AL/83/18/UMA

Application for a non-material amendment following a grant of planning permission.

Non-material amend ment
following the grant of
AL/102/17/RES for
amend ment to carports for
plots 27, 207 & 208 +
addition of garage doors to
each of the 9 No. carports

WSC-A-4673-A-PT22-30A

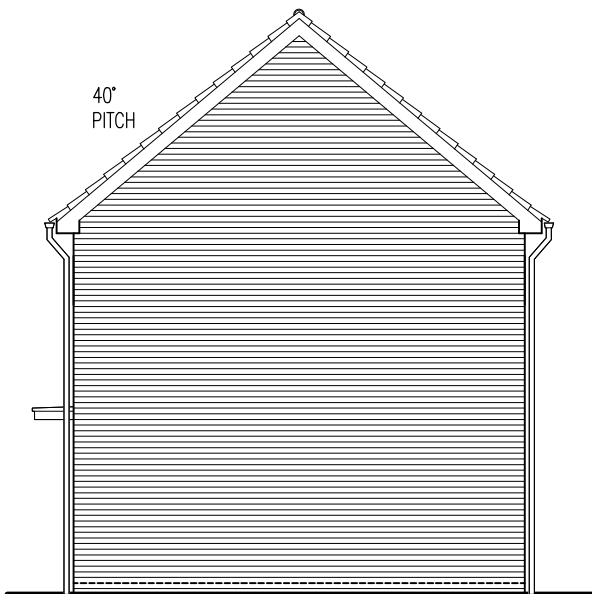
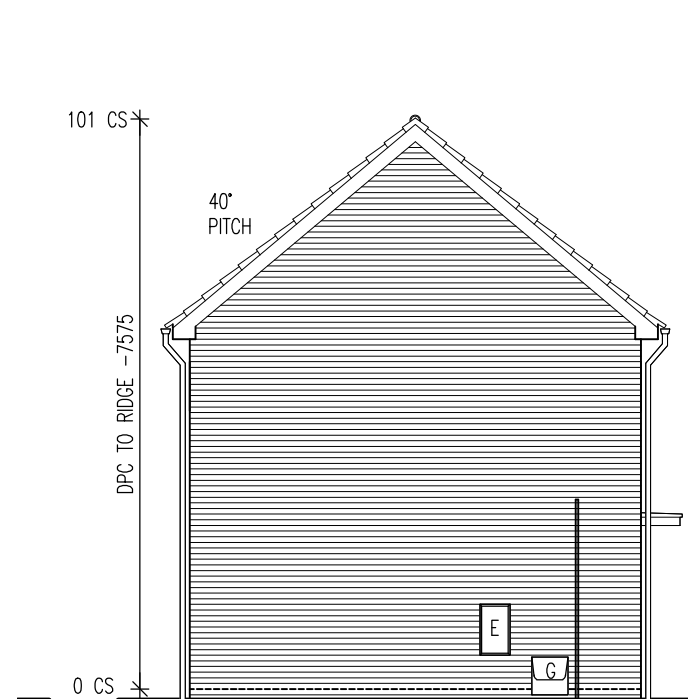
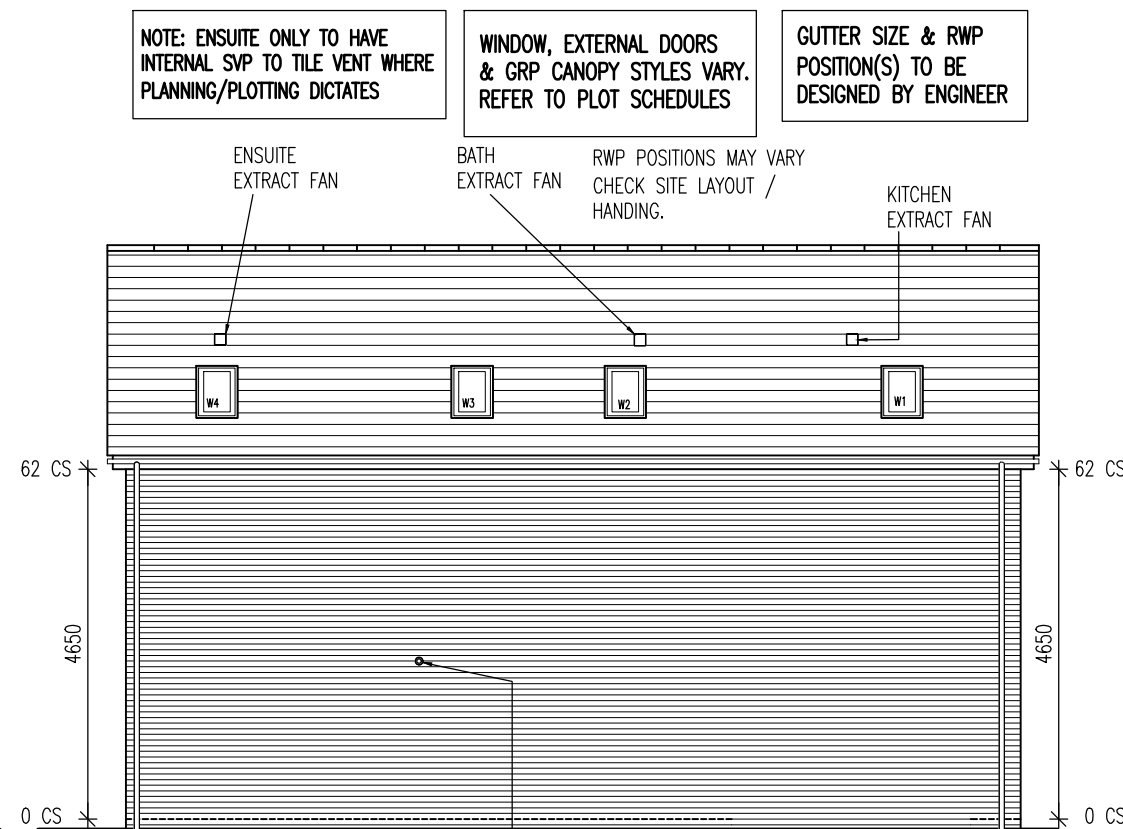
Amendment to carports under plots 27, 207 & 208 addition of garage door to each of the 9 carports.

WSC-A-4673-A-PT22-21B
WSC-A-4673-A-PT22-30A
WSC-A-4673-A-PT22-31

HOUSETYPE PLANS AND ELEVATIONS
PT22 (EDALE)
PLOT 27, 207, 208 as shown

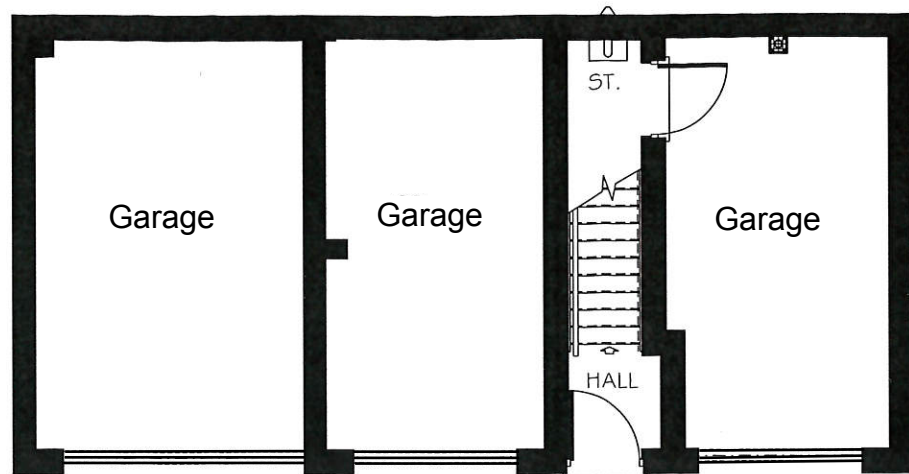
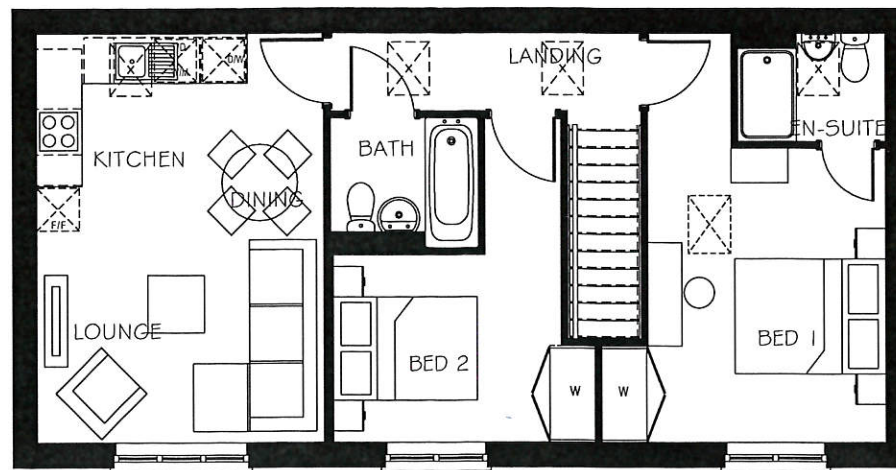
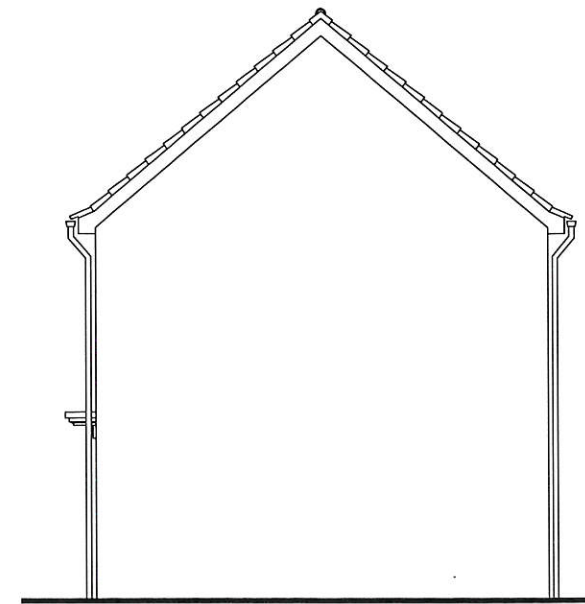
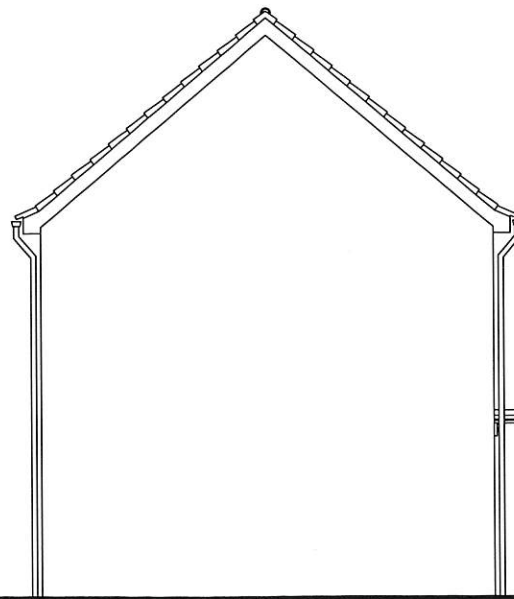
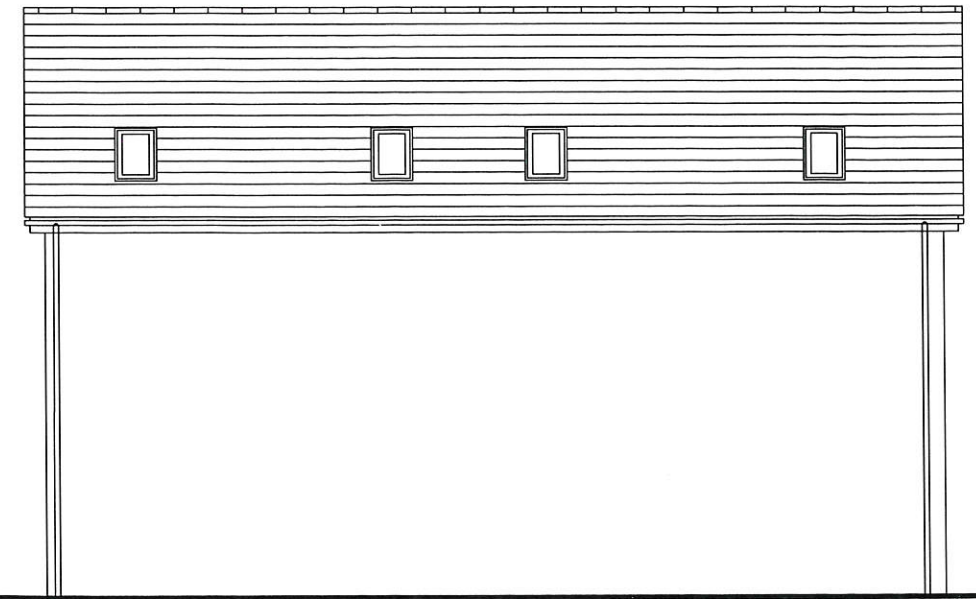
LHG 59650-115 A
